**Updated Acoustic Assessment and Report
Proposed Preschool & Community School – 1 Rosemead Road, Hornsby, NSW**

I refer to our recent communications regarding the above matter, and in particular to the updated acoustic report prepared by NG Child & Associates, and a further alternative and counter report prepared on behalf of your neighbour at 1A Rosemead Road by Noise and Sound Services.

TF1 - TIMBER FENCE TO 1800MM HIGH TO ACOUSTIC CONSULTANT REQUIREMENTS. FENCE TO SLOPE DOWN TO 1200MM AT BOUNDARY WHERE APPLICABLE.

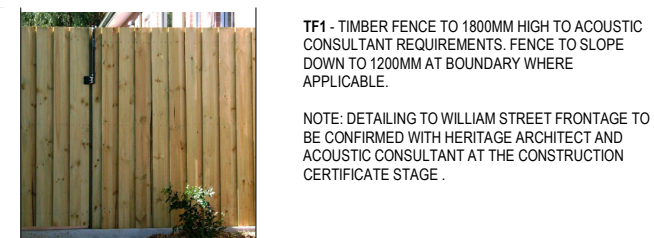
Acoustic protection will be provided by distance; the acoustic boundary fence, and the operational and behavioural controls to be set out in the Noise Management Plan component of the overall Plan of Management for the Centre.

Further, in my opinion, the currently proposed controls will ensure appropriate and compliant noise impacts at the adjoining 1A Rosemead Road residential boundary.

It is noted that while not considered likely to be required, additional acoustic protection for the 1A Rosemead Road residential boundary can quickly and easily be provided by the inclusion of 400 -600 mm clear plastic extensions to the section of boundary fence in question.
